From: Sue Howell <Sue.Howell@arun.gov.uk>
Sent: 20 April 2021 16:45
To: Planning.Responses <Planning.Responses@arun.gov.uk>
Cc: Simon Davis <Simon.Davis@arun.gov.uk>
Subject: Planning Consultation on: Y/22/21/PL

Response to Planning Application

Description: Change of use from existing open barn to 1 No. dwelling (C3 Dwelling House), refurbishment & single storey extension to North elevation (renewal of permission Y/60/16/PL, amended with Y/53/19/NMA). This site is in CIL Zone 3 and is CIL Liable as new dwelling & may affect the setting of a listed building.

Location: North Barn Hoe Lane Flansham PO22 8NT

Drawing P02 January 2021 Scale 1:20 & 1:100 @ A3
Proposed Drawing - Site Plan & Fence Details

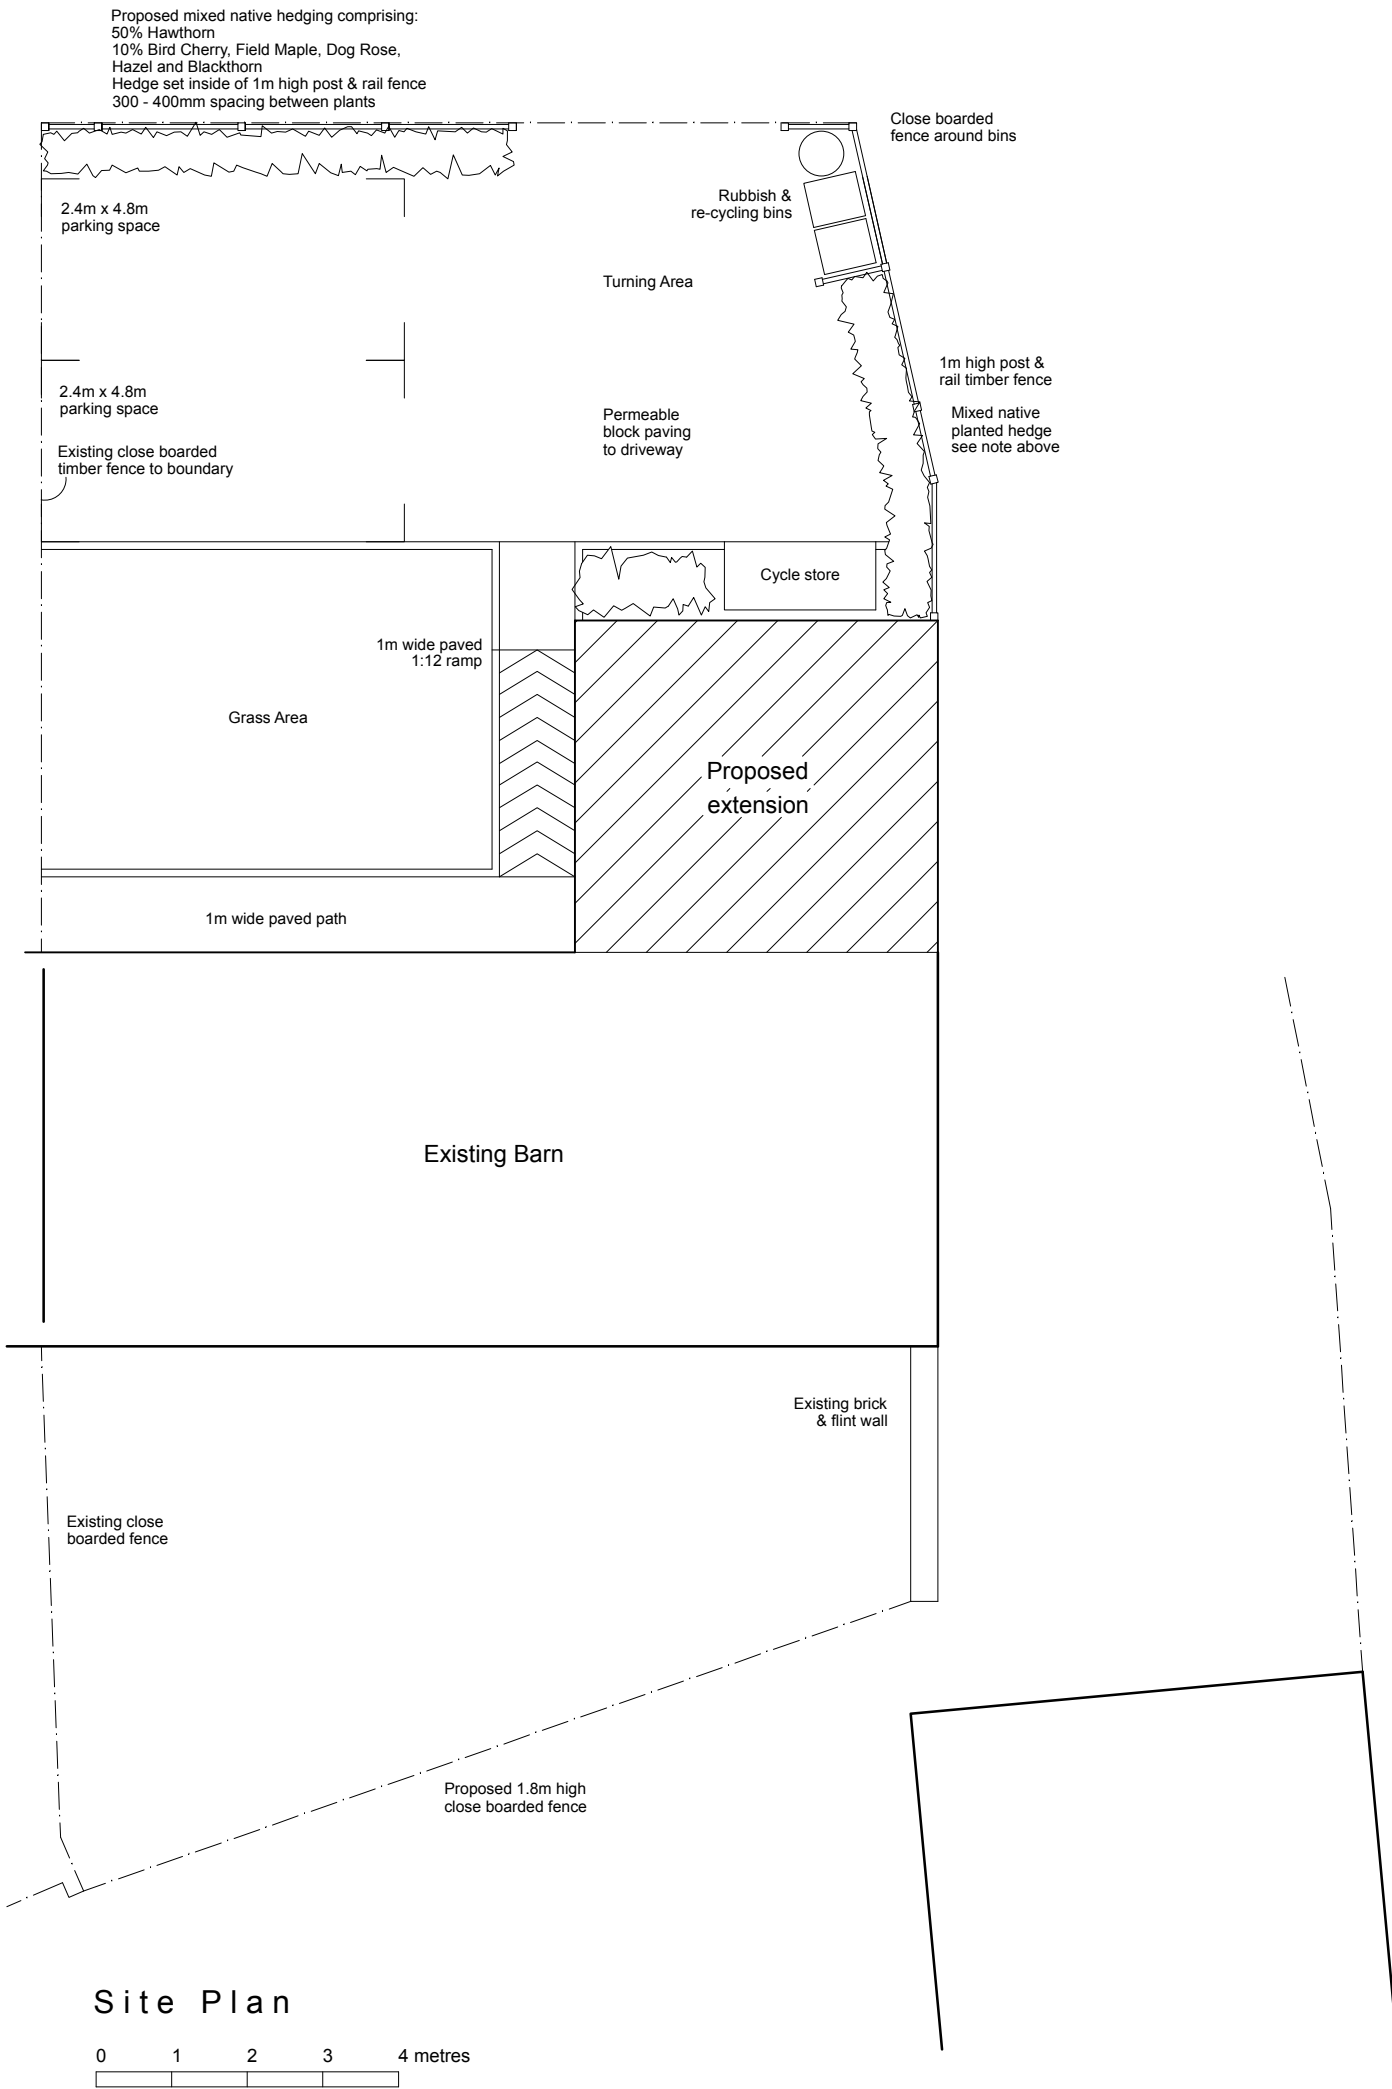
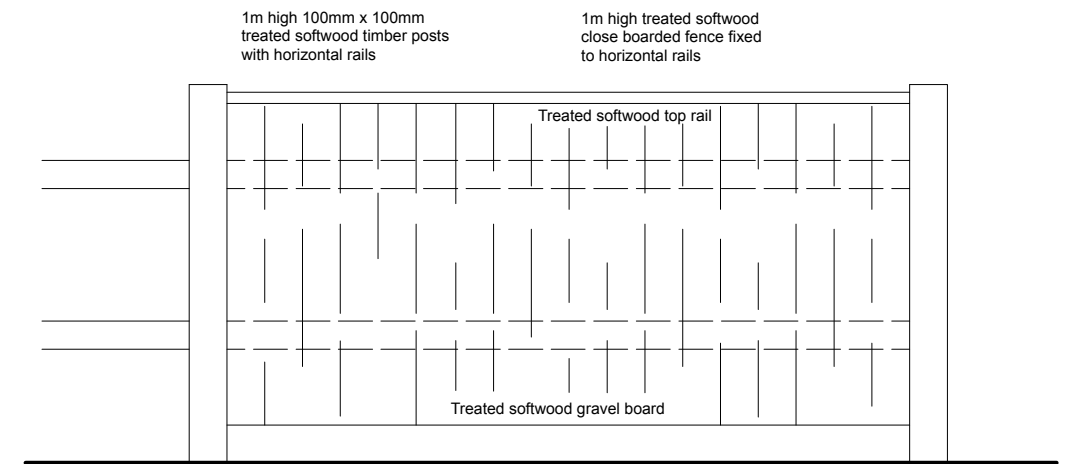
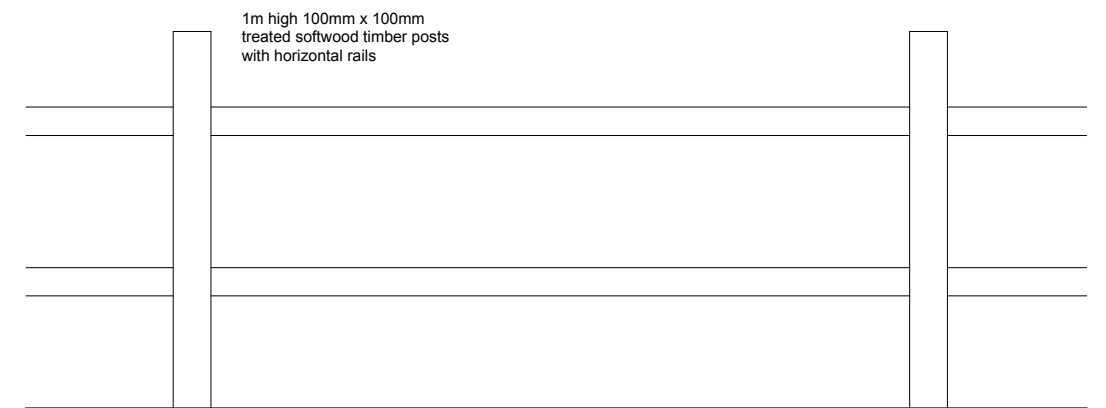
The Drawing P02 Architectural Design & Drawing Service January 2021 Proposed Drawing - Site Plan & Fence Details has shown proposed planting to screen and soften the development. These details regarding species choice and specification would appear suitable for location. The areas indicated for mixed native hedging will require the quantities of each species to be specified and added to the this drawing for clarity.

I would recommend no landscape objection to the proposals, recommend the submission of quantities to be confirmed for the mixed native hedge planting.
